Nepean Hospital - Acoustic Logic Response to NSW EPA and Penrith Council Comments

This letter has been prepared in response to comments made by the NSW EPA and Penrith City Council in the response letters regarding the revision 7 SSD Acoustic Assessment (dated 23/07/2018) for the Stage 1 redevelopment of the Nepean Hospital.

Letter references received are NSW EPA; *DOC18/664903-02*, dated 11th October 2018 and Penrith City Council; ECM 8375601, dated 12th October 2018.

Figure 2 – Noise Survey

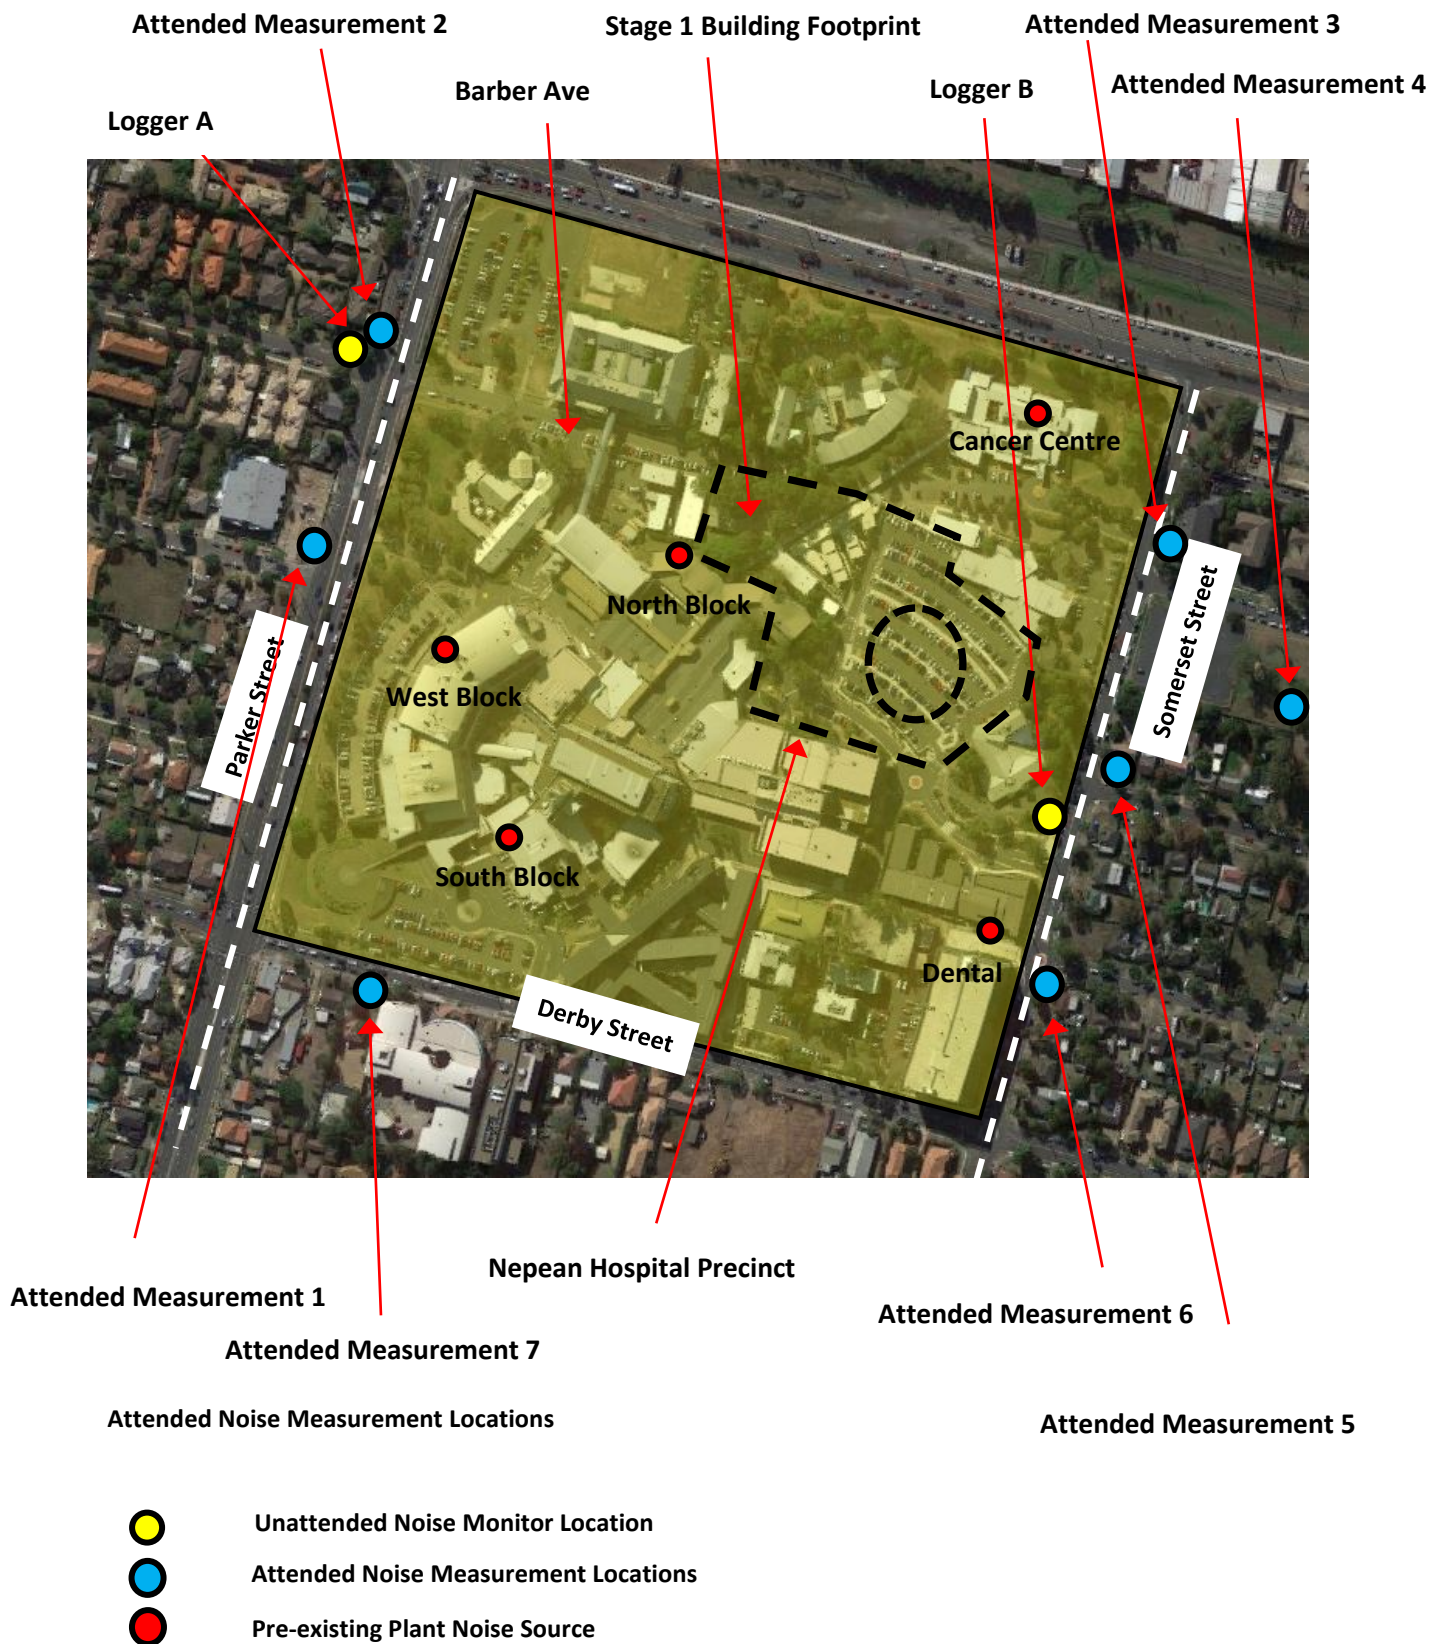
However, Figure 2 to EIS Appendix 15 indicates that 2 noise loggers were deployed for the purposes of background noise monitoring.

Logger A was deployed at a residence in Barber Street over 11 days between 31 January 2017 and 10 February 2017 but no meteorological data is reported.

However, Logger B was deployed -

- (a) between 25 May 2018 and 1 June 2018 during which period background noise measurements were likely to be affected by rain on 28 and 30 May as well as wind speeds in excess of 5 metres per second on several days, and
- (b) on the hospital campus instead of at the most affected or potentially most affected residence in Somerset Street.

The EIS is not supported by a graphical representation of the daily background noise monitoring data and observed meteorological conditions.

Accordingly, the EPA is unable to provide an informed assessment of the suitability of the rating background levels and applicable noise criteria.

- A revised report has been provided (Revision 9 Dated 08/11/2018) which includes the graphed results of the background noise monitoring for both logger locations A (Barber Street) and B (Somerset Street). Meteorological data has been included in the graphs in accordance with the NSW EPA NPfI 2017 to highlight times when logging data was excluding from analysis (during rainfall and wind speeds that exceed 5 metres per second).

- In regard to Logger Location B (Somerset Street), we make the following comments.
 - Comments have been provided by the EPA in relation to logger location B and the fact that it was not undertaken at the *most affected or potentially most affected residence in Somerset Street*.

- As explained in section 4 table 2 of the Acoustic Assessment, during our site attendances (in particular, the 6/6/2018 measurement at 12am-2am) it was observed that existing mechanical plant from the Hospital is affecting the background noise levels along most of the Somerset Street residences.

- In accordance with the NPfI, noise from an existing development should be excluded from background noise measurements.
 - All residences on Somerset Street are impacted to some degree by pre-existing plant noise (as detailed table 2). Most critically, the residences at the northern end of Somerset Street are impacted by plant noise from the existing Cancer Centre. This

applies to both the residences directly opposite (the nearest potentially impacted) as well as residences further to the east (see attended measurement locations 3, 4 and 5, page 9).

- Further, it is likely that the existing plant noise will change following the development of the hospital, meaning that a measurement of ambient noise levels at a location not impacted by existing plant noise is desirable.
- The noise Somerset Street logging location (Location B) that was used is the location on Somerset Street that is not impacted by existing plant noise (as it is shielded by the child care centre) and best represents the ambient environment excluding noise from the Hospital itself.
- The location selected was appropriate for use when setting noise emission limits. In fact, it was the best location on Somerset Street for this purpose.
